PLANNING CONSULTATION RESPONSE

Application No	2025 0908
Proposal	Re-engineering and restoration of Yew Tree Quarry
Address	Stairfoot Brickworks, Wombwell Lane, Stairfoot
Date of Consultation Reply	09/04/2026
Consultee	BMBC PROW - S Ford

VIEWPORT 3 - SWEEP PATH ANALYSIS (SCALE 1:1000@A1)

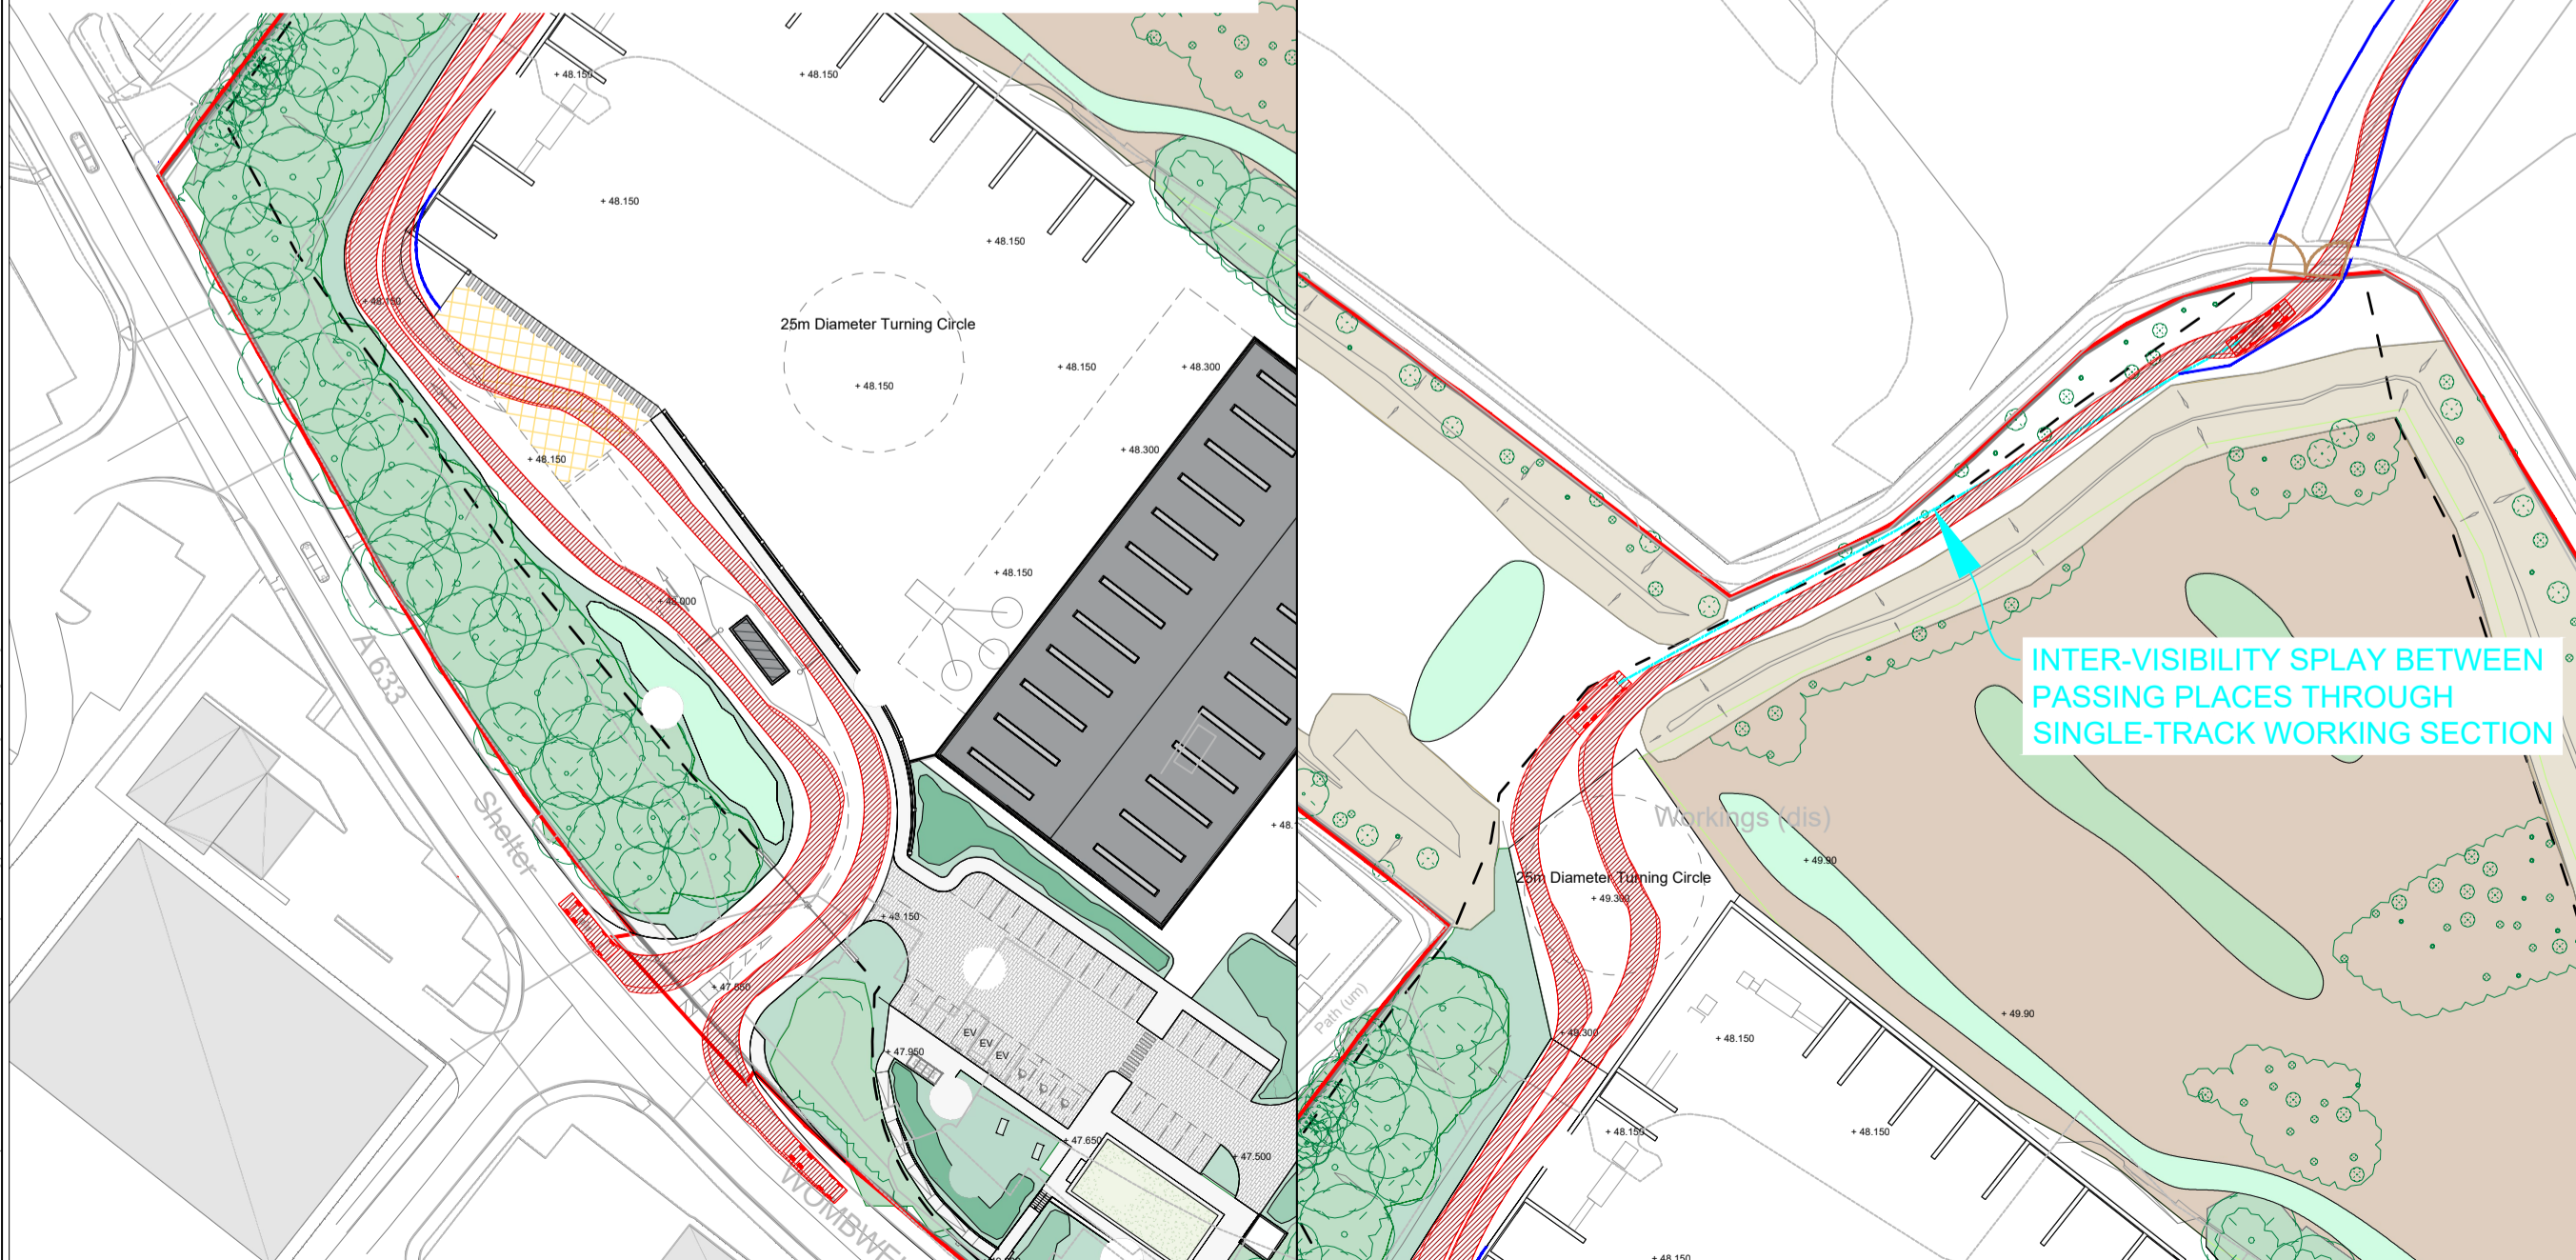
Not sure what this adds in relation to TPT or PROW but the TPT crossing is covered in the Delivery management plans
